From: Fiona Fitzgerald [REDACTED]
Sent: 08 September 2021 10:44
To: Planning.Responses [REDACTED]
Cc: Michael Eastham [REDACTED]
Subject: BE/110/21/DOC

TITLE
Saltbox, Bognor Regis
NMA Planting Plan 2 of 3

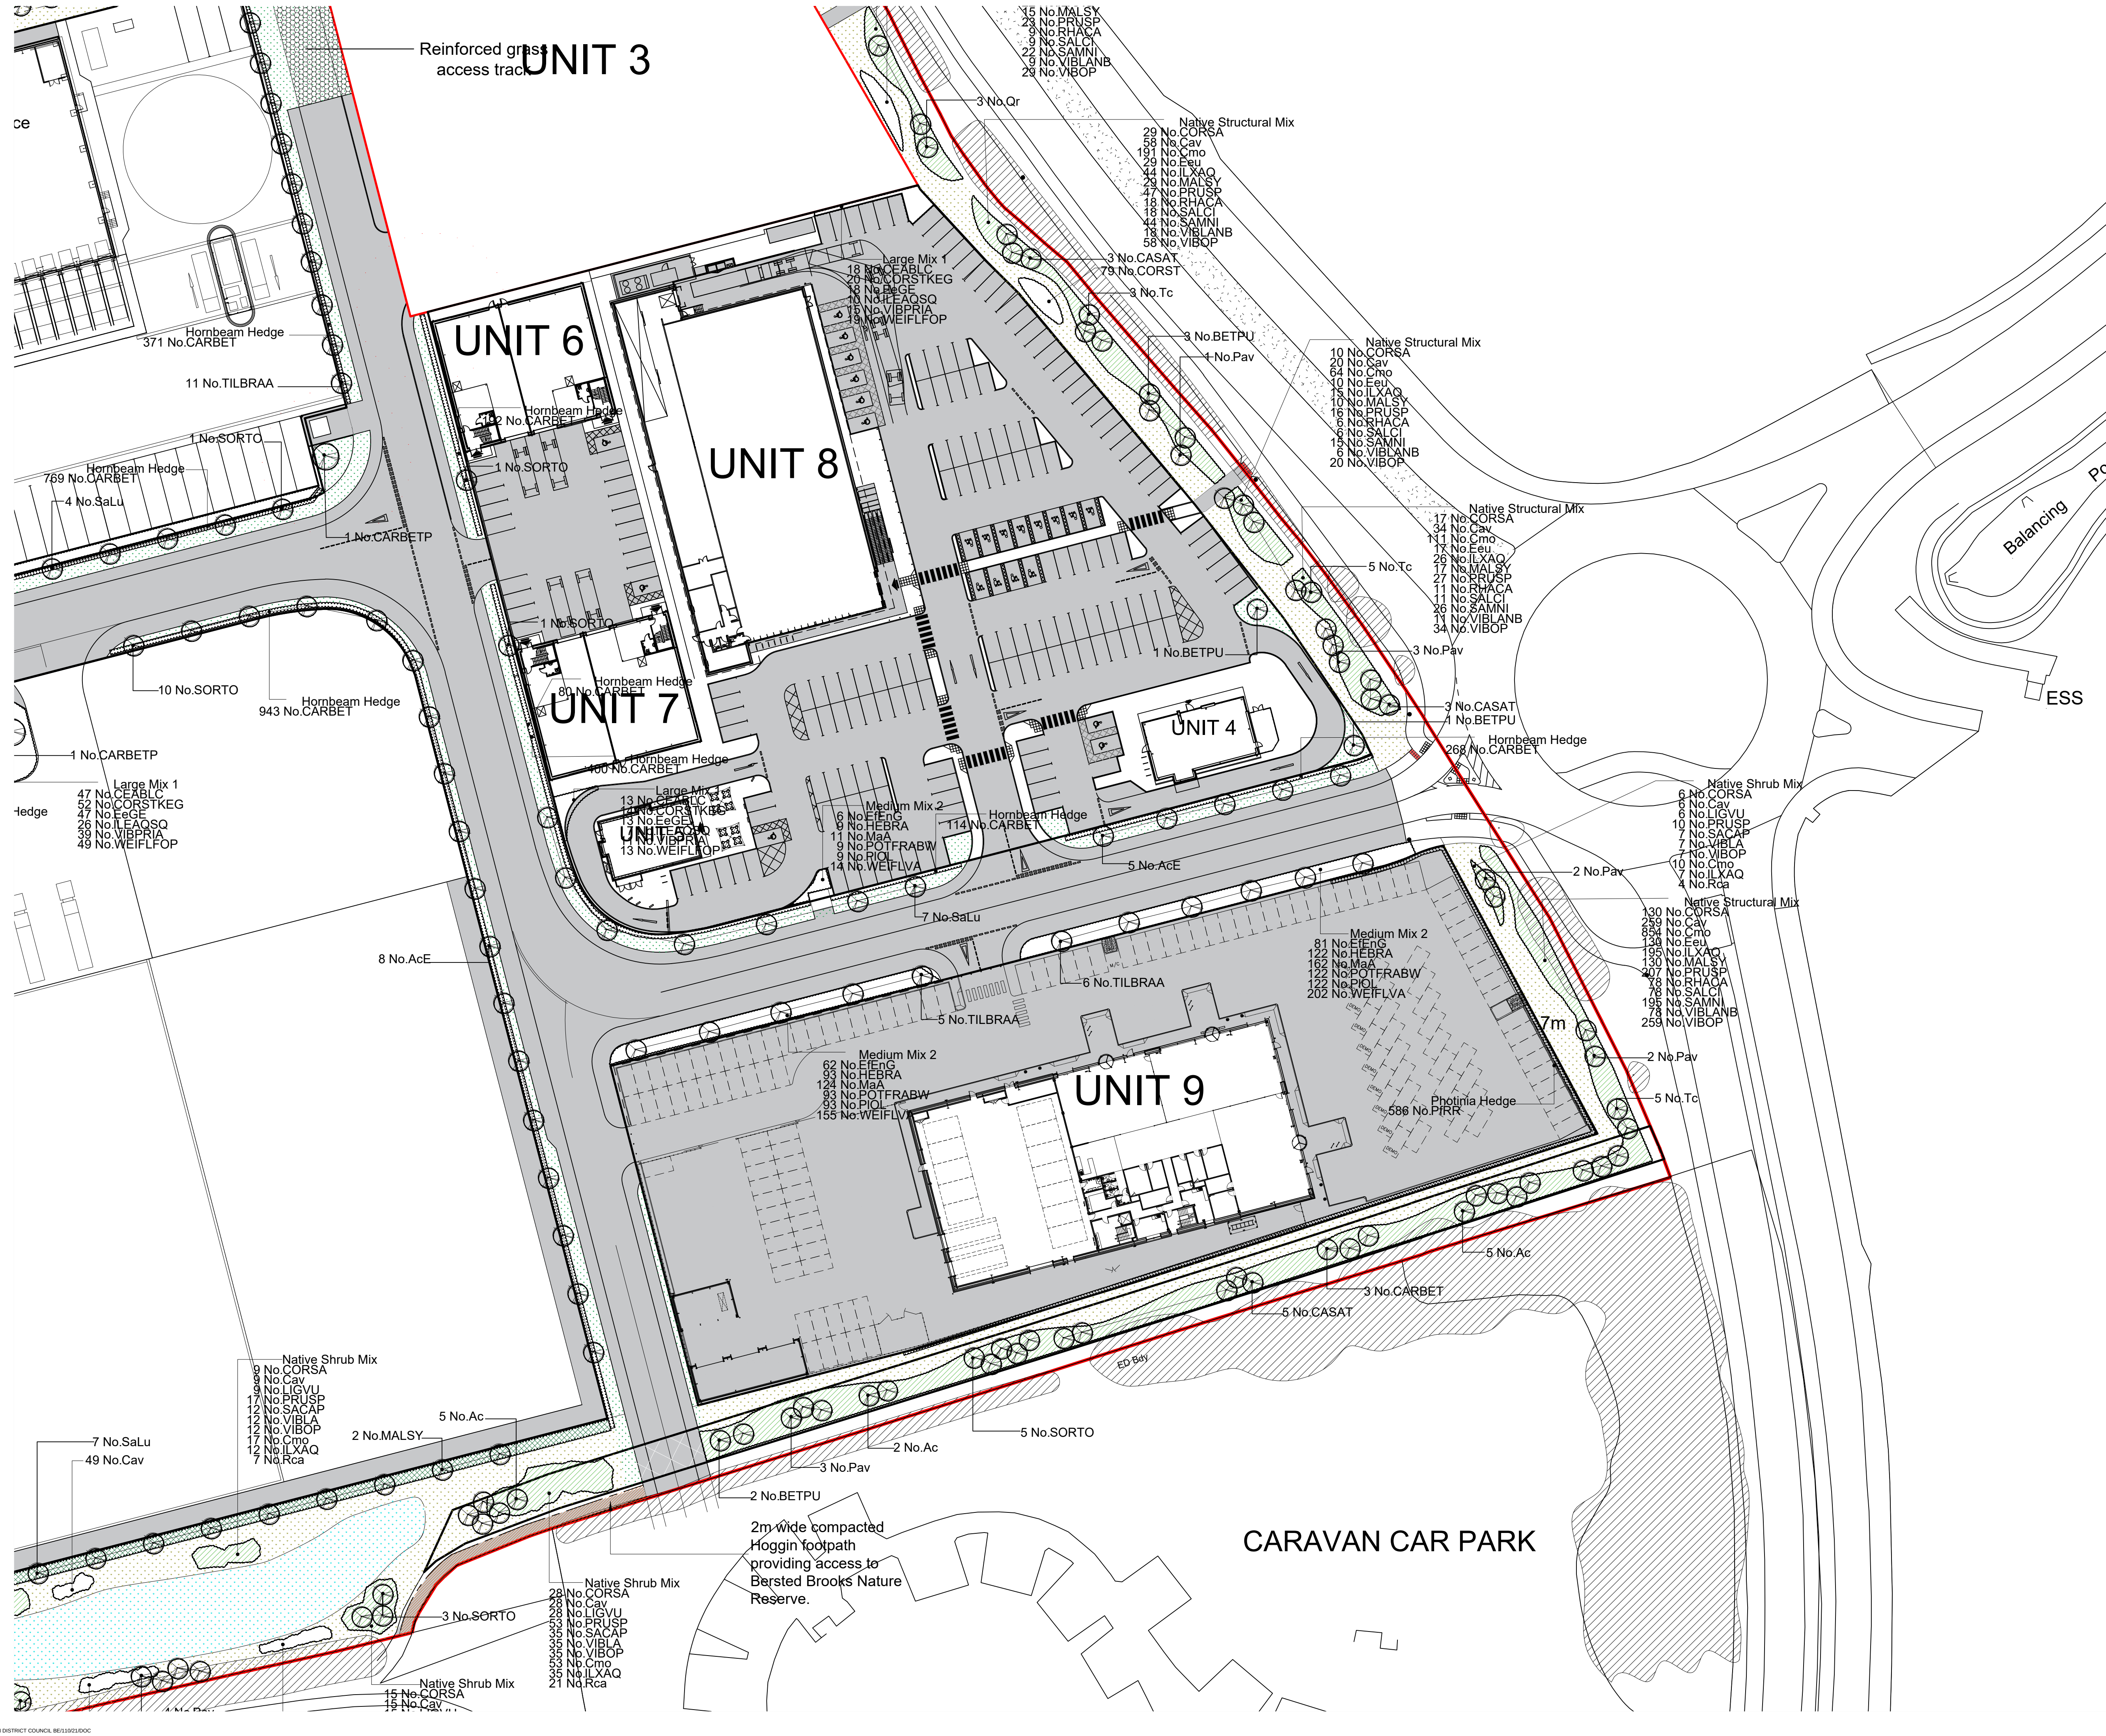
The landscaped bund that was proposed to be constructed immediately to the north of Unit 3 has been removed from the plans. This bund was in place as part of the noise mitigation to protect the residential dwellings to the north of the site. Environmental Health **objects** in the strongest possible terms about the removal of this bund.
